# ENG-SF20028-R3-Plat.pdf Markup Summary

**Subject:** Callout  
**Page Index:** 1  
**Date:** 6/25/2021 1:33:45 PM  
**Author:** dsdparsons  
**Color:** ■  
**Layer:**  
**Space:**  
**Page Label:** [1] 2021-05-10 - Constitution & Hannah PLAT-S1

SHEET 1 OF 8

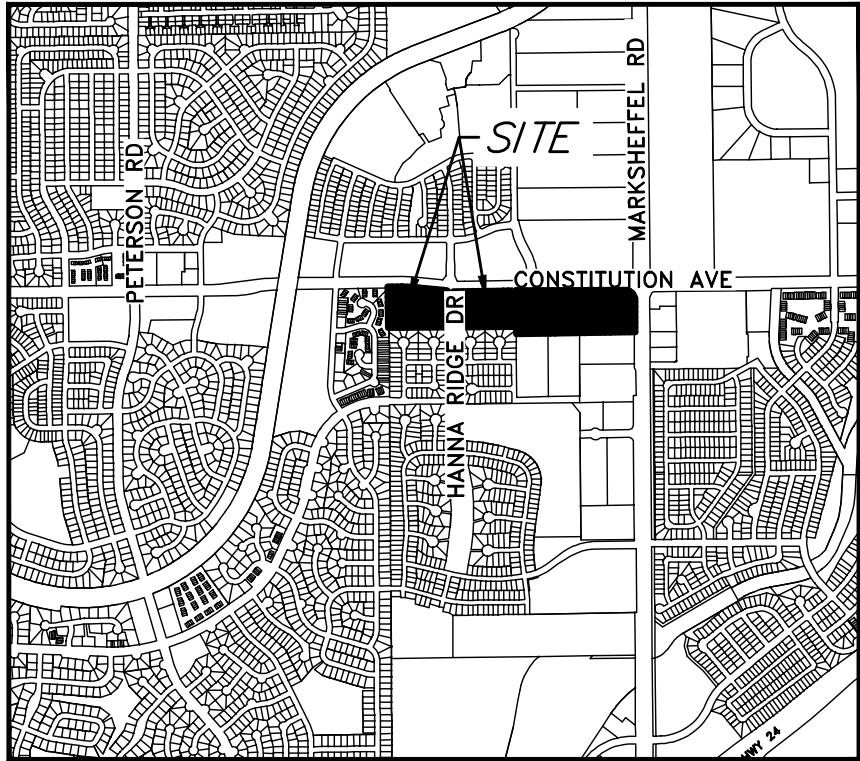
these go to lower right corner; i have never seen them in upper area of document

what is this for? Is there an entity named secretary treasurer that has an interest in ownership in property?

i though these were attached units ? buildings cant be built over easements

Please add the note: This plat has been reviewed and approved by Enumerations as recorded at reception number \_\_\_\_\_ in the records of the El Paso County Clerk and Recorder's Office.

SHEET 2 OF 8

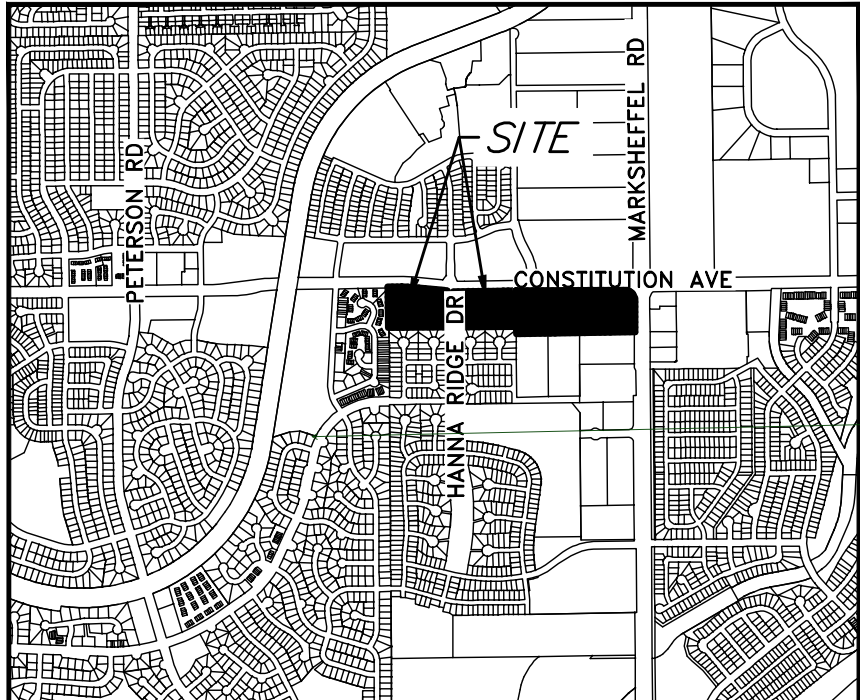
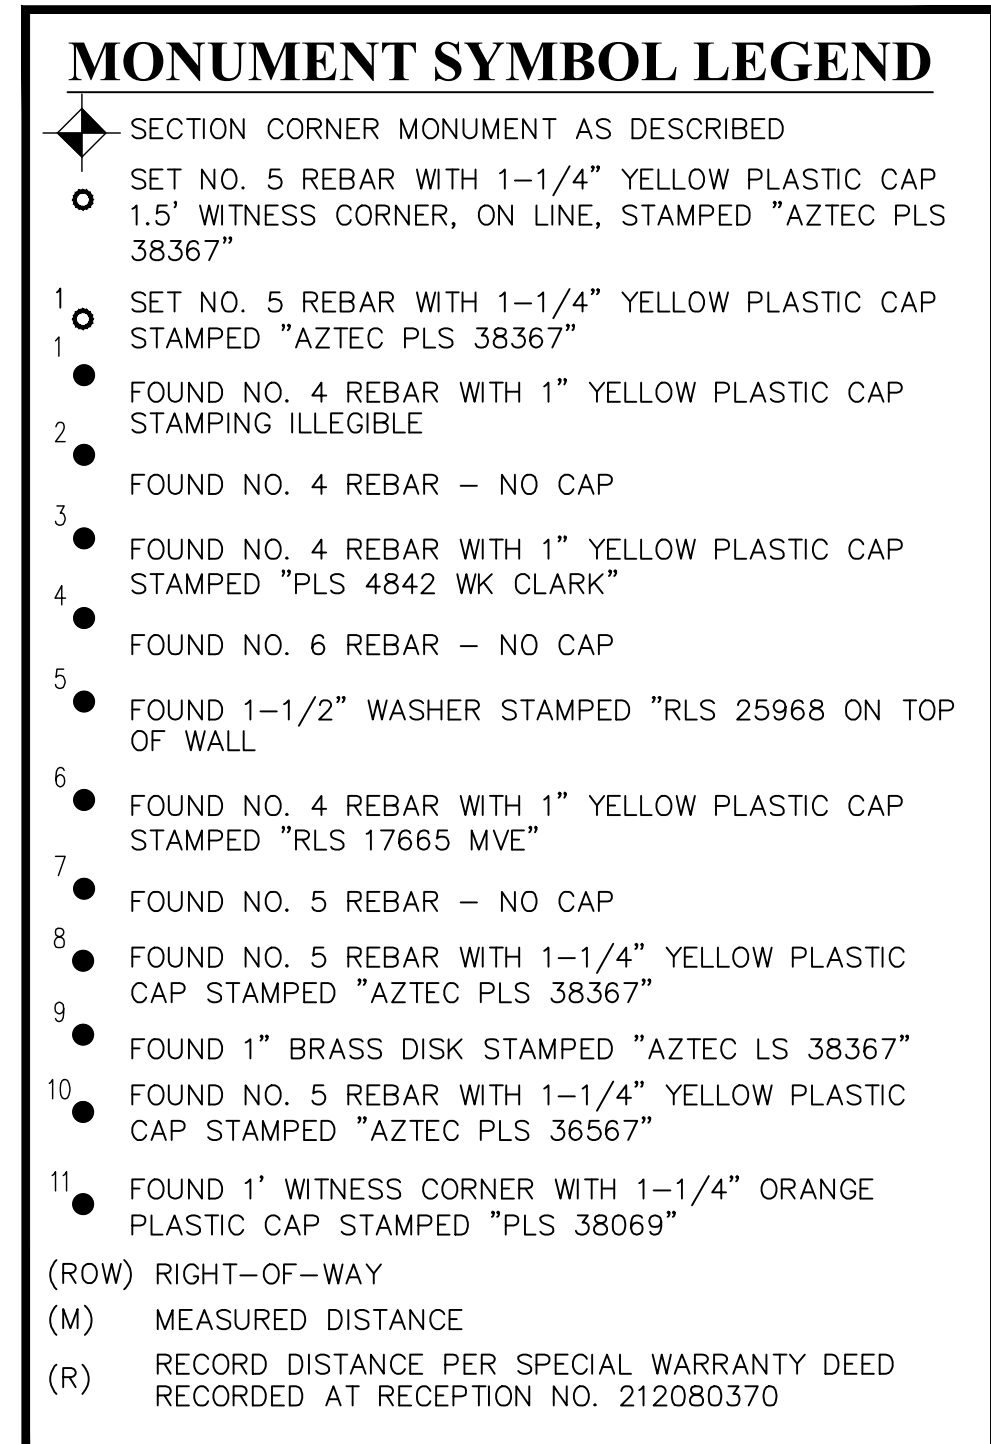
delete this vicinity map off second page please

NOT correct

Please copy note for note 24' please do not change

delete note 39; note no. 9 is the correct note

this will be a challenge perhaps w blanket easements.... what no grading in easements- the site has an avigation easement and blanket easements are proposed ? I would delete this note.

Where is this note from? CSU is only gas here....This is not a standard note: I recommend deleting it.

please prepare and upload the complete deeds for legal review and exhibits for the conveyance w resubmittal.

delete highlighted portion and replace with a sentence stating the HOA is the maintenance entity.

replace with "Parks and"

Add note:  
 The Developer of Tract M shall be responsible for reconstructing the emergency access connection of Blue Avena View to Akers Drive when Akers Drive is constructed.

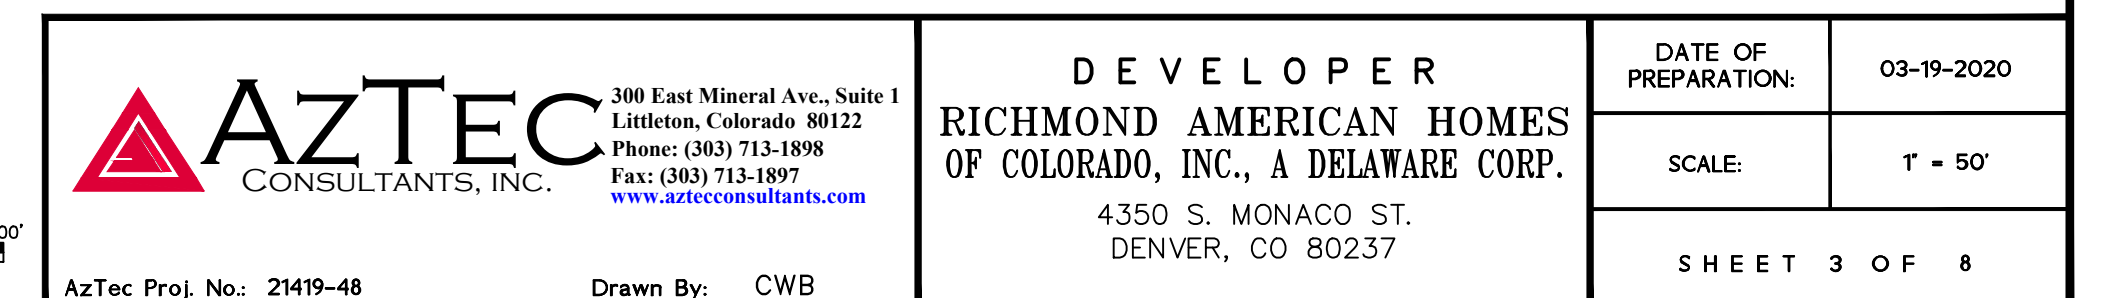
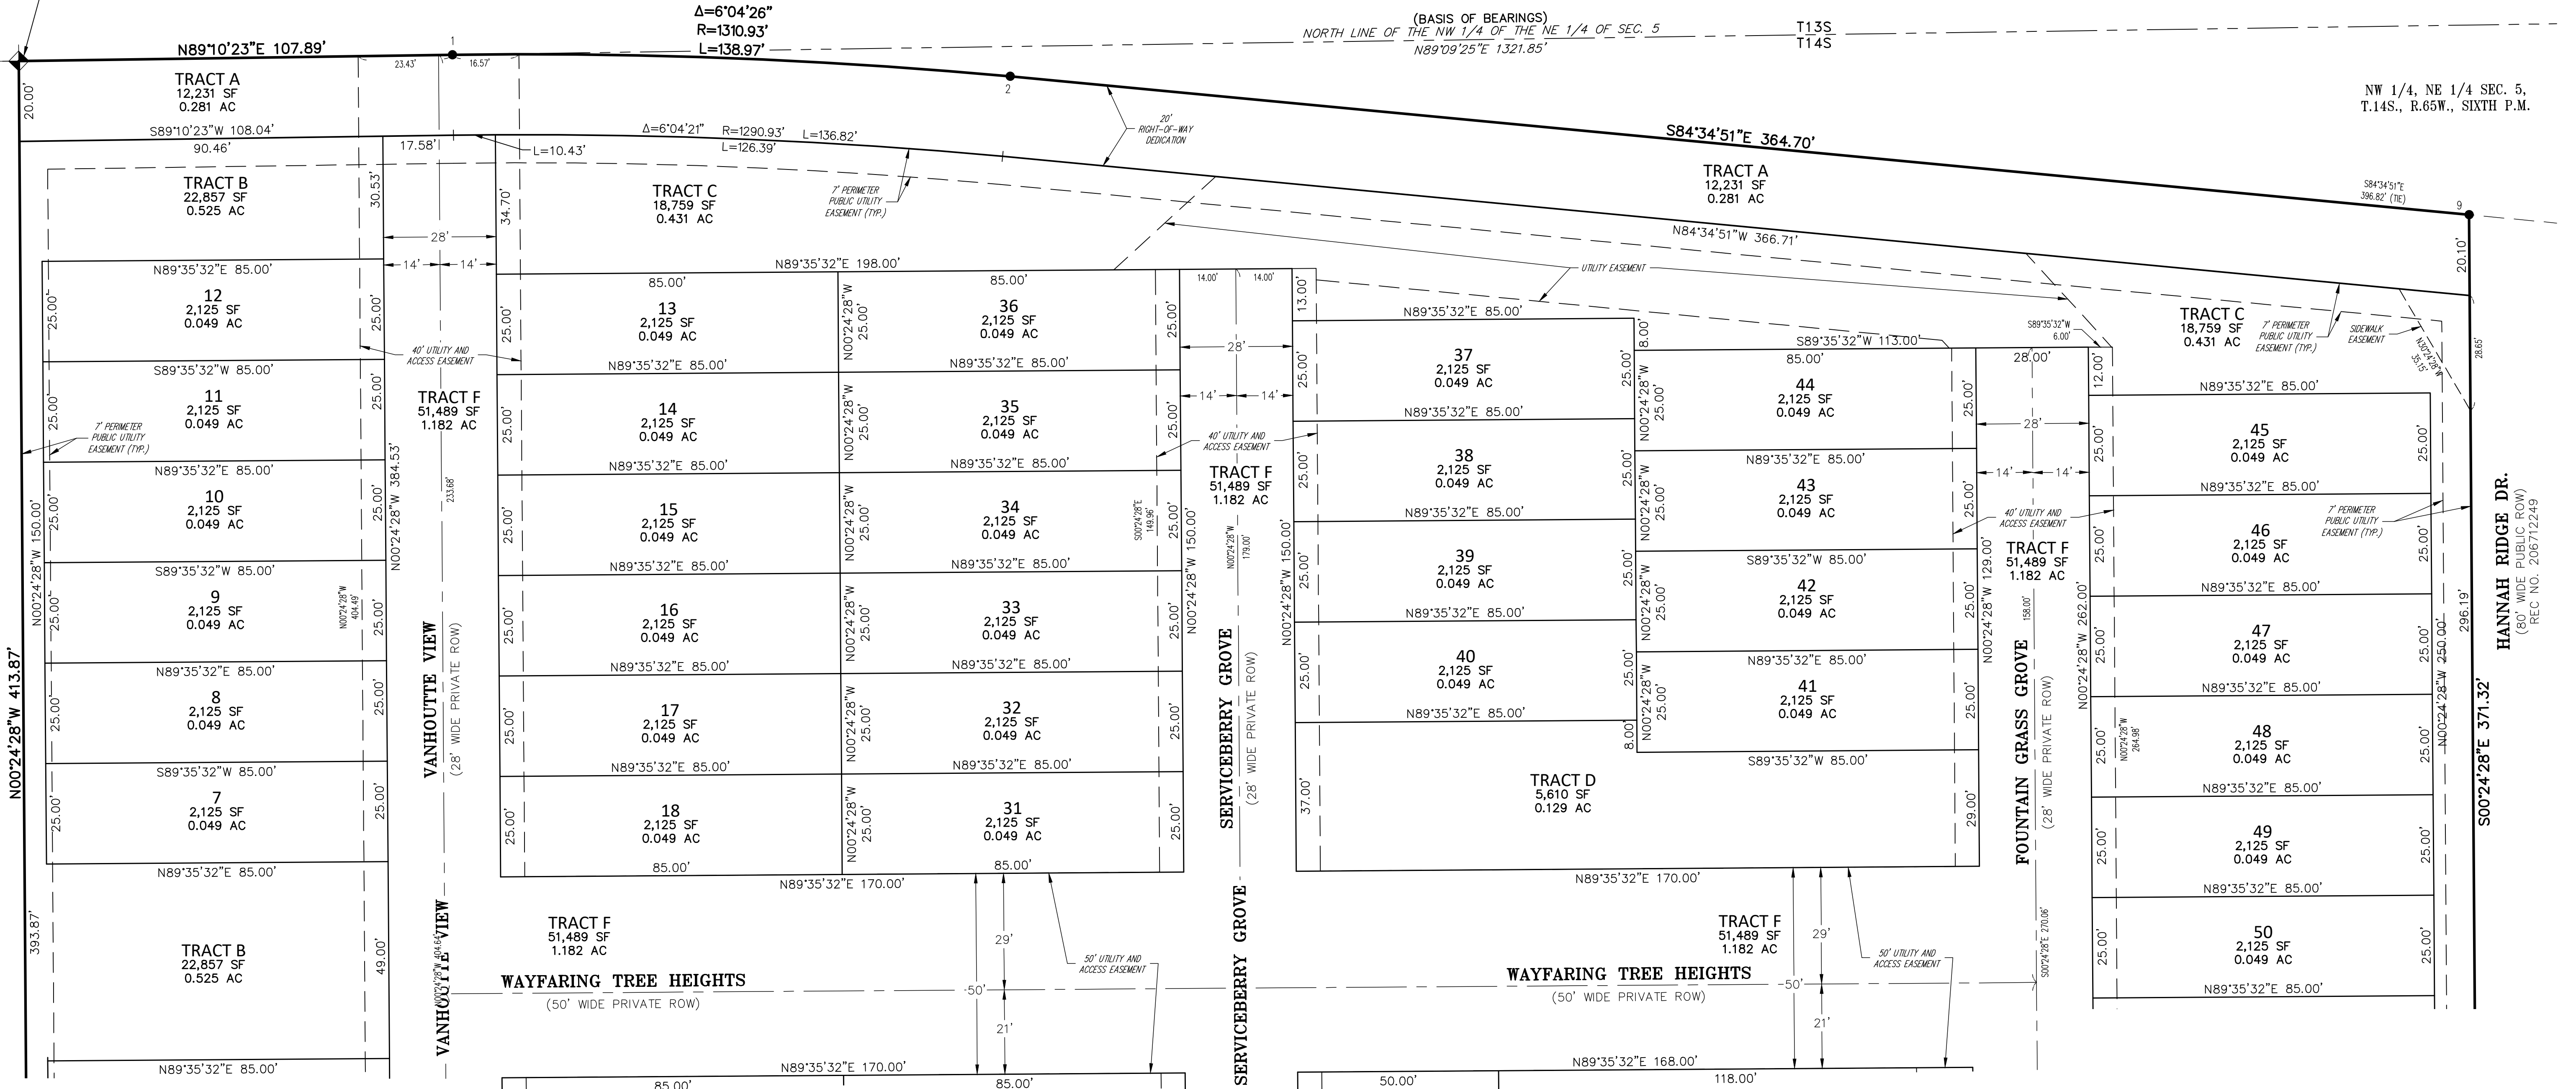
NOTE - Closure sheets should close all tracts and all lots as well as boundary; please update closure sheets
